# CITY OF ALBUQUERQUE

**RE: District 505 Tower 10 Apartments  
Grading and Drainage Plan  
Engineer's Stamp Date: 6/8/2024  
Hydrology File: K18D114**

Based upon the information provided in your submittal received 6/10/2024, the Grading & Drainage Plan **is not** approved for Building Permit. The following comments need to be addressed for approval of the above referenced project:

C-100

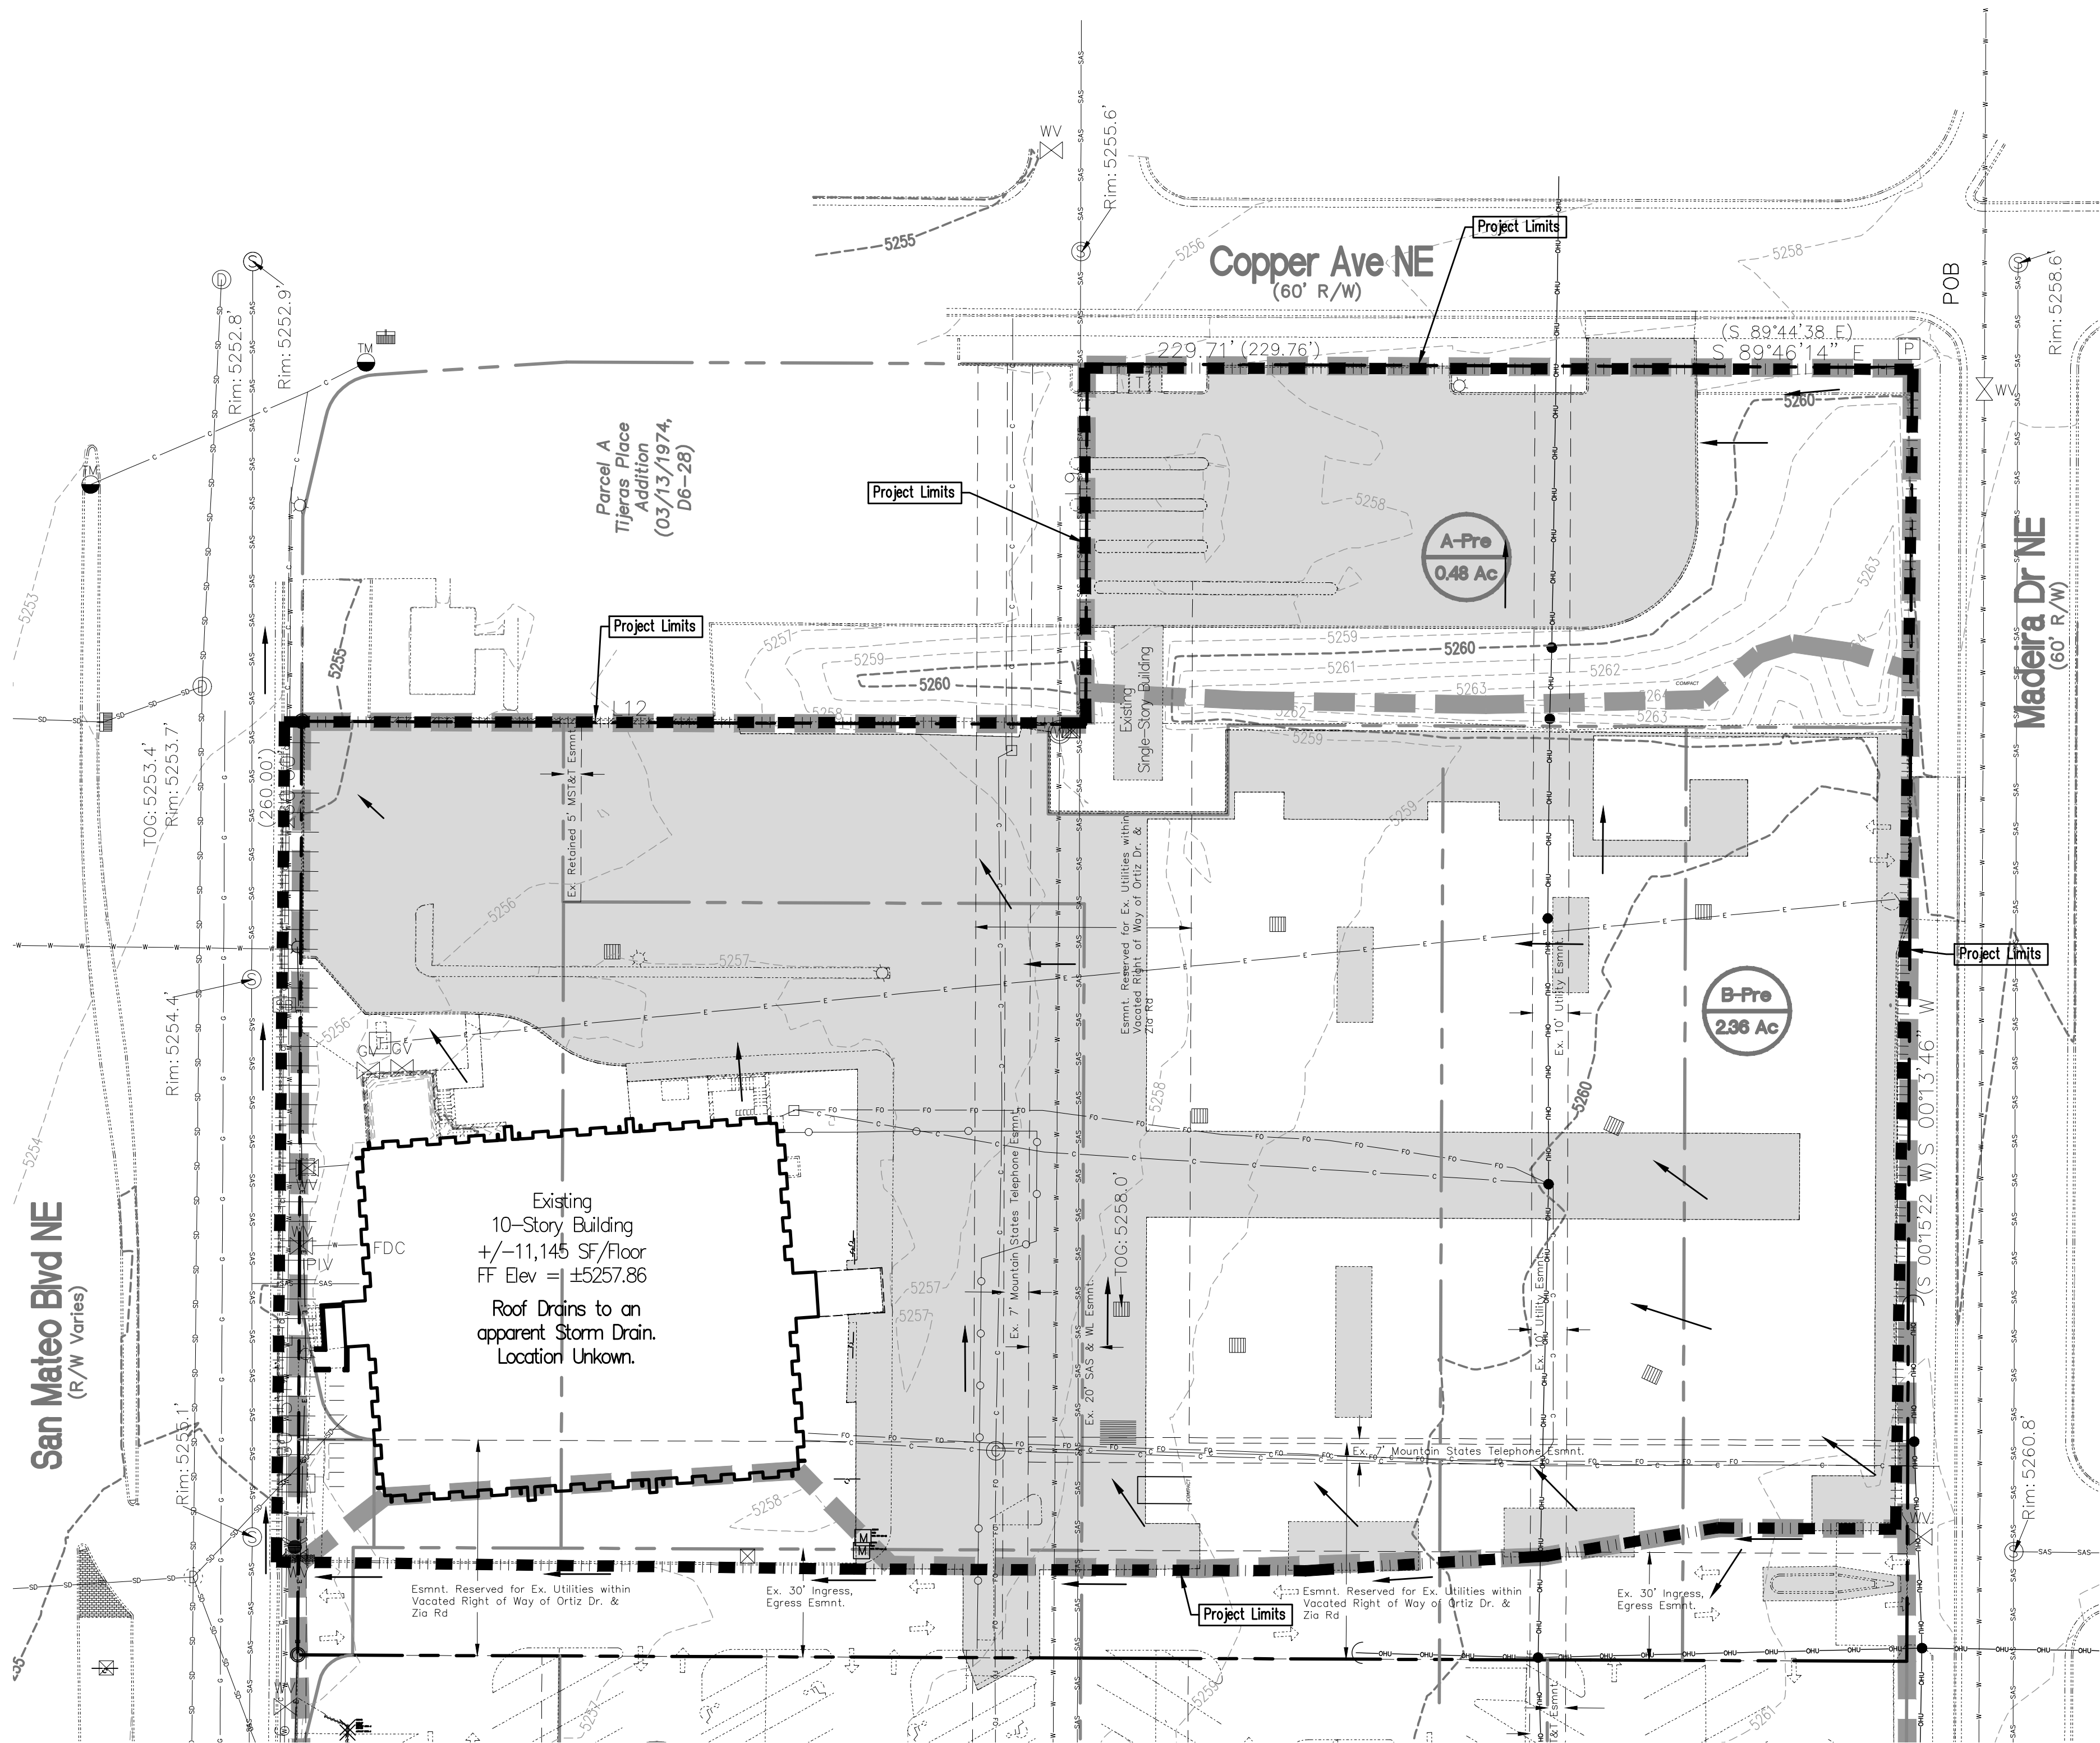
1. Provide a cross section of the ponds to show water surface elevations, outlet elevations, inlet elevations and SWQV elevations.
2. On sheet C-100, the southern SWQ pond is missing the volume. Please include this in the plan.

4. Sheet C-100 contains a note about a separate WO / SO-19 permit and also a notice to the contractor about the SO-19 work in the ROW. Will the SO-19 work be included in this project? Both notes seem to conflict with the scope. If the SO-19 work will be included, then the following notes need to be added to the Notice:

- a. Contact Storm Maintenance at (505) 857-8033 to schedule a meeting prior to forming.
  - b. Contractor must contact Storm Maintenance at (505) 857-8033 to schedule a construction inspection. For excavating and barricading inspections, contact Construction Coordination at (505) 924-3416.

C-101

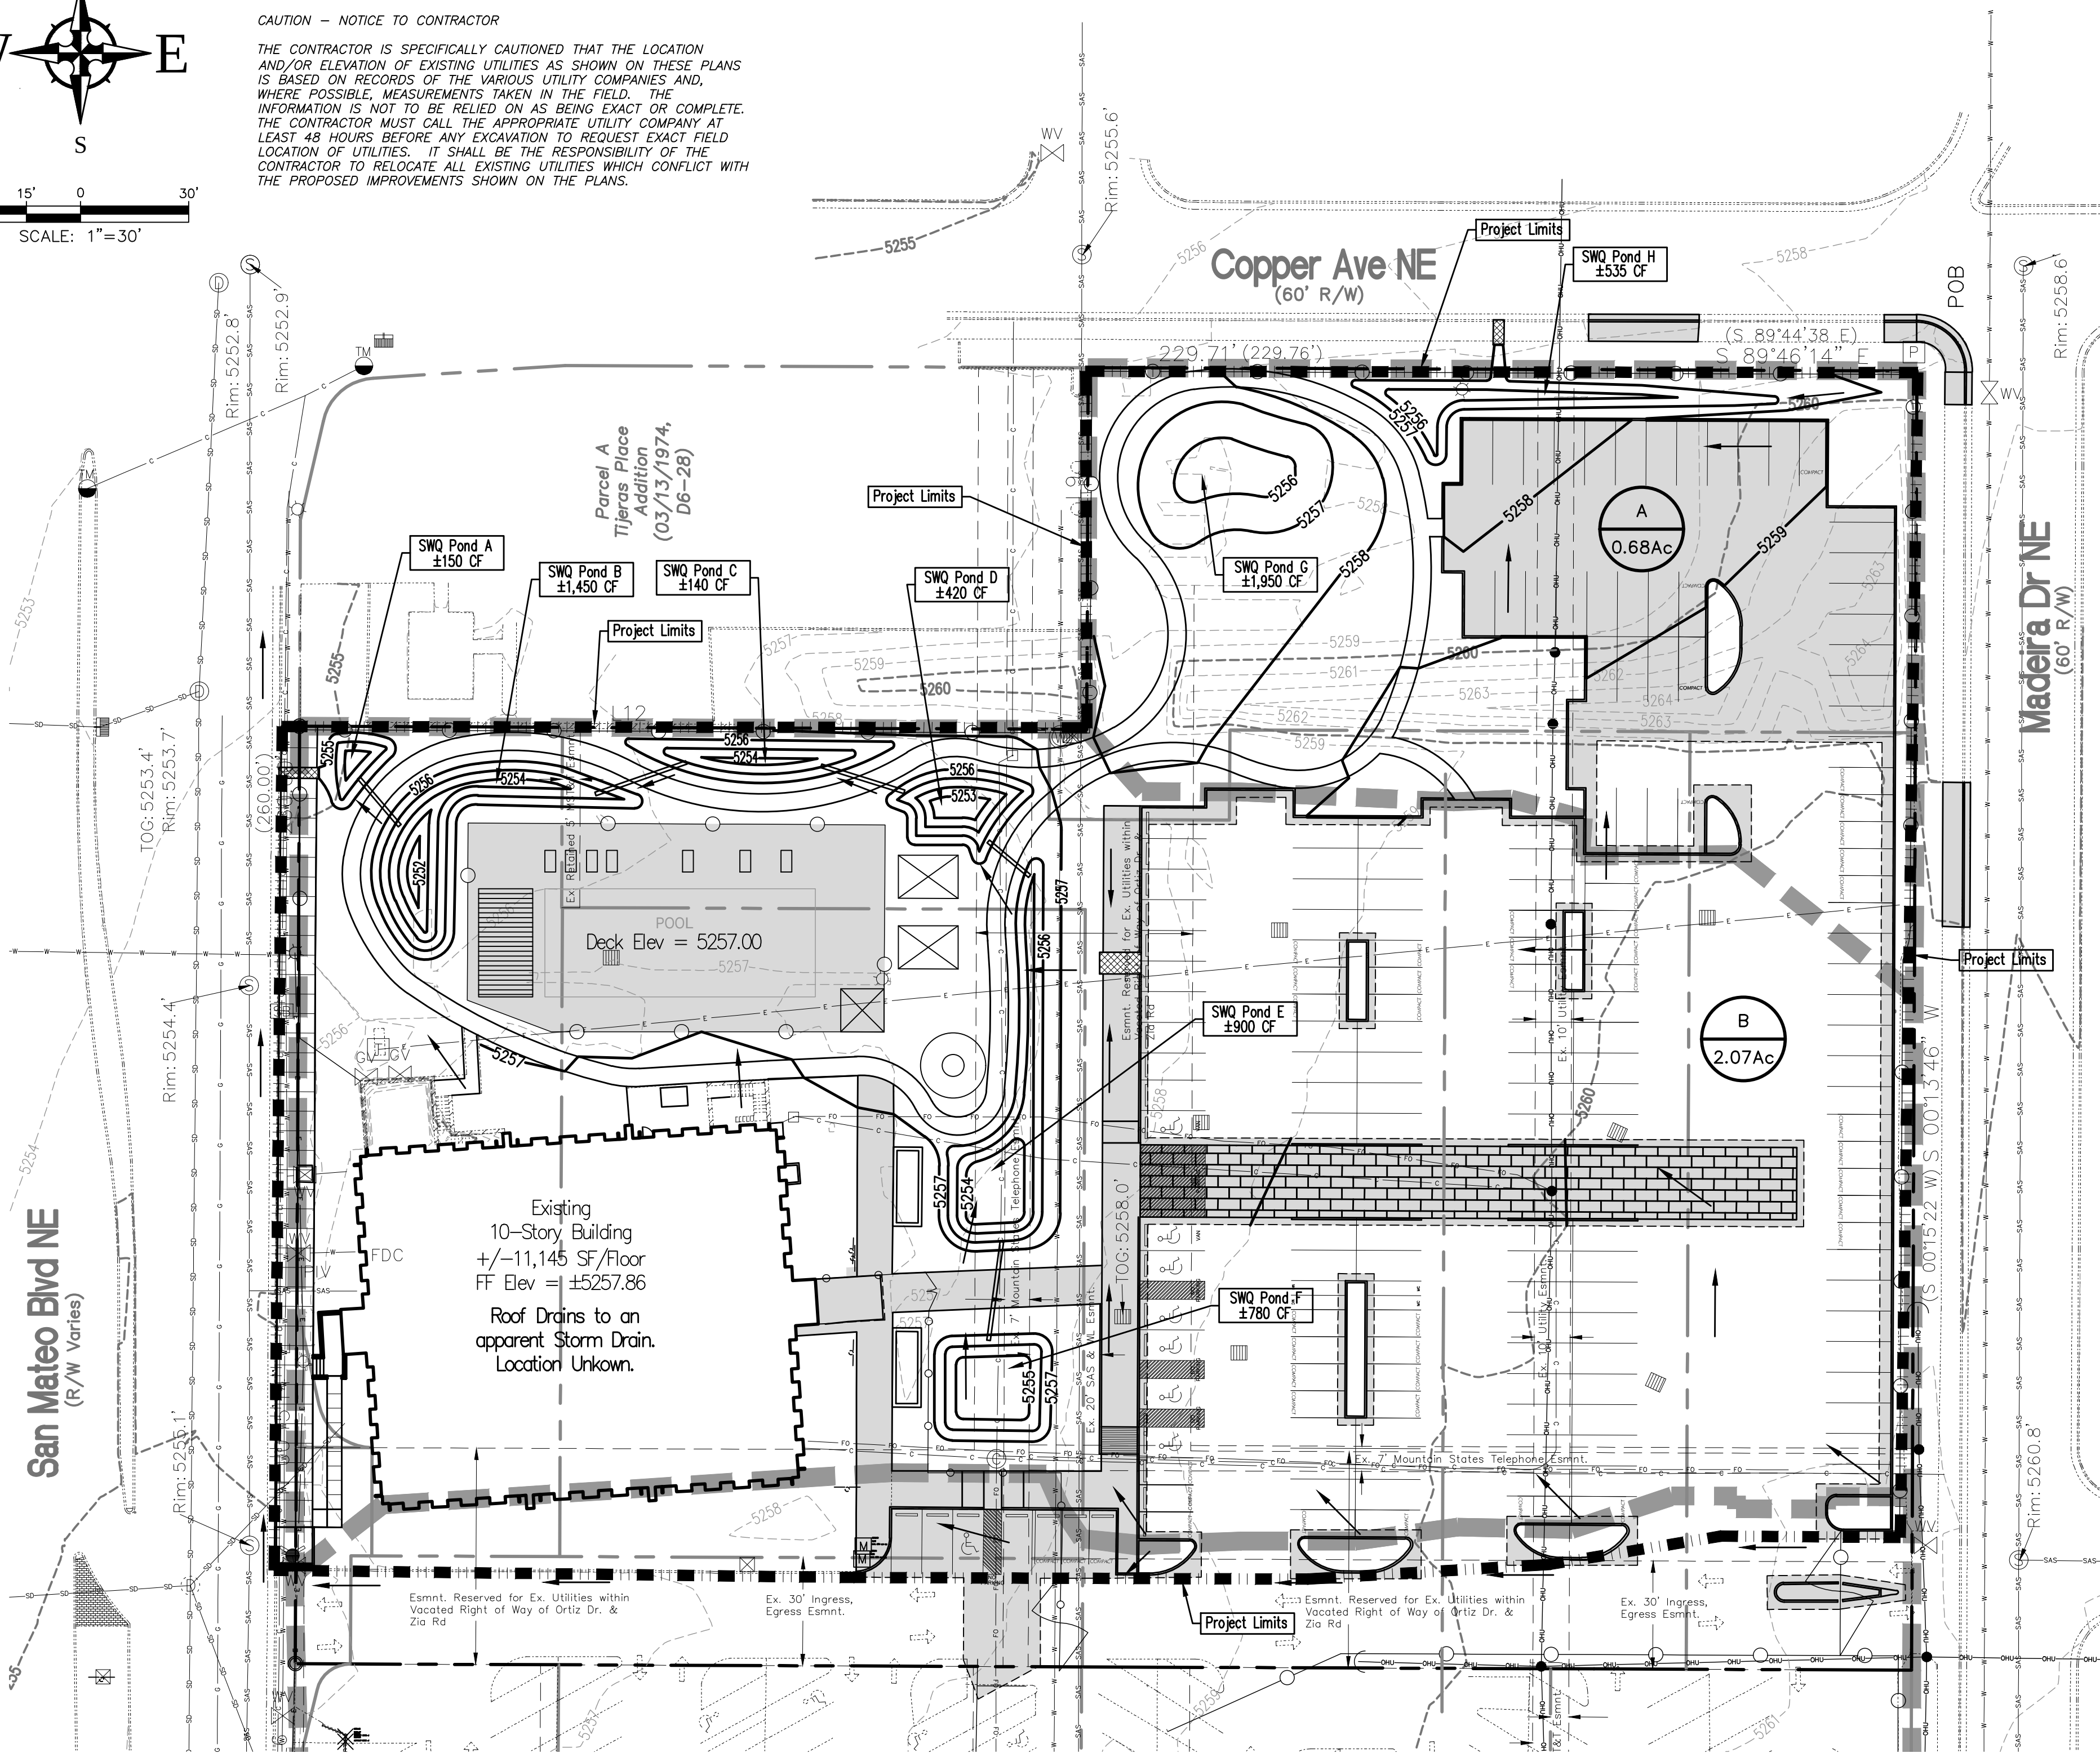
3. On sheet C-101, the Basin 'B' Water Quality Pond Calculation shows 3,060 CF as the total volume provided. This volume adds up to the volume of the 5 ponds shown but does not add in the 6<sup>th</sup> (southern) pond in this basin. When the volume is added (from comment #1) to the plan, please verify the calculation for the total volume provided.

5. Please review the calculations for  $V(100)_{10\text{Day}}$  for both the Pre-Developed and Post Developed conditions. Per the DPM (Equation 6.5 in Section 6-2(A)(4) ) for 10-day storms:  $V_{10\text{DAYS}} = V_{360} + A_D \cdot (P_{10\text{DAYS}} - P_{360}) / 12 \text{ in/ft.}$
